CITY OF ALBUQUERQUE
PLANNING DEPARTMENT
DEVELOPMENT REVIEW BOARD

Project# 1010204

14DRB-70288 SITE DEVELOPMENT PLAN FOR BUILDING PERMIT
14DRB-70324 SIDEWALK VARIANCE

RE: Tract Q7A1-A, Atrisco Business Park Unit 4

REVISION DATE
STATE OF NEW MEXICO RICHARD P. BENNETT No. 1240 REGISTERED ARCHITECT
RBA ARCHITECTURE, P.C. ARCHITECTURE, P.C. PLANNING DESIGN
DATE 08-11-2014
SHEET NUMBER C-1.0

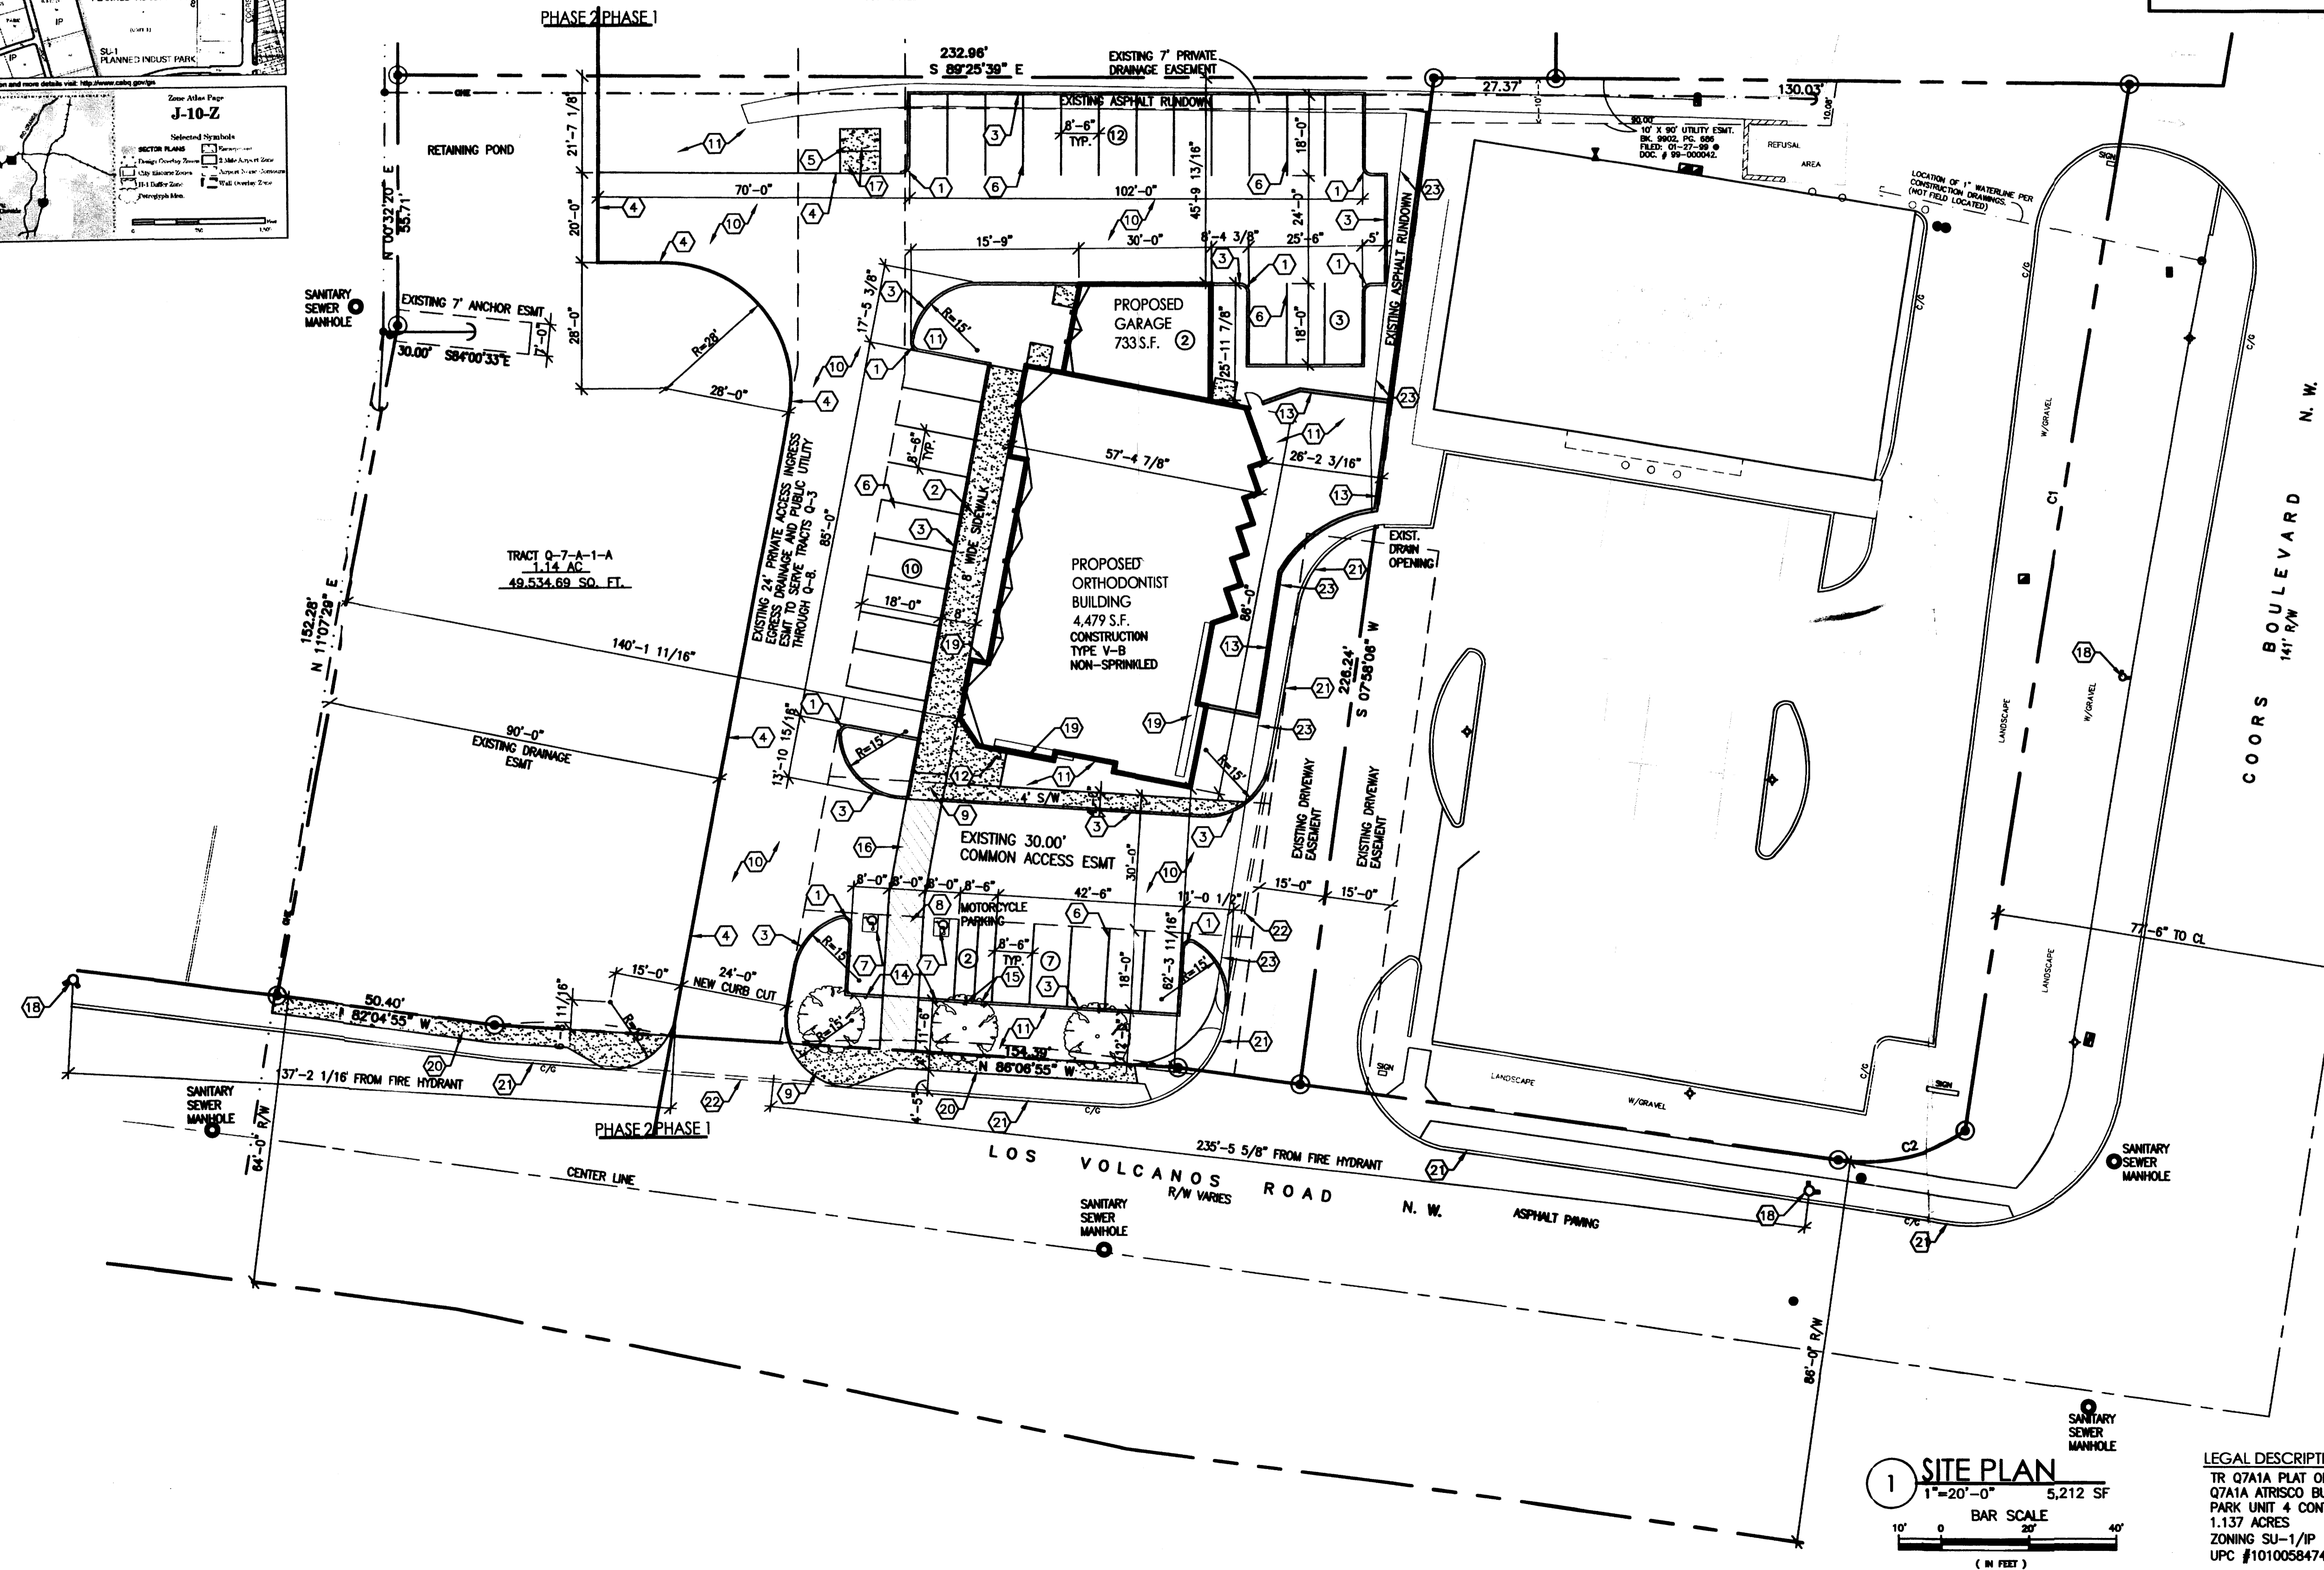
- 1) Recording information of existing easements needs to be noted on the site plan; also note if easements are 'Proposed.'
- 2) Patio wall color/ elevation needs to be noted in the site plan packet.
- 3) Landscape calculation table needs to be for 20% per Master Plan; landscaping is required along the south and east edge of the 90 foot Drainage Easement on the western portion of the site.

Provide an exhibit showing the location of sidewalk and defining the distance from back of curb to the property line. Right of way dedication may be required.

Los Volcanes Road is a collector in this area. As such, drives with full access require a 36-foot minimum width and a 20-foot minimum radius. In addition, collector roadways require a 6-foot wide sidewalk with a 6-foot setback from back of curb.

Provide recording information for the existing easements.

Show all ramps and provide details.

Provide a legend defining all hatching and linetypes.
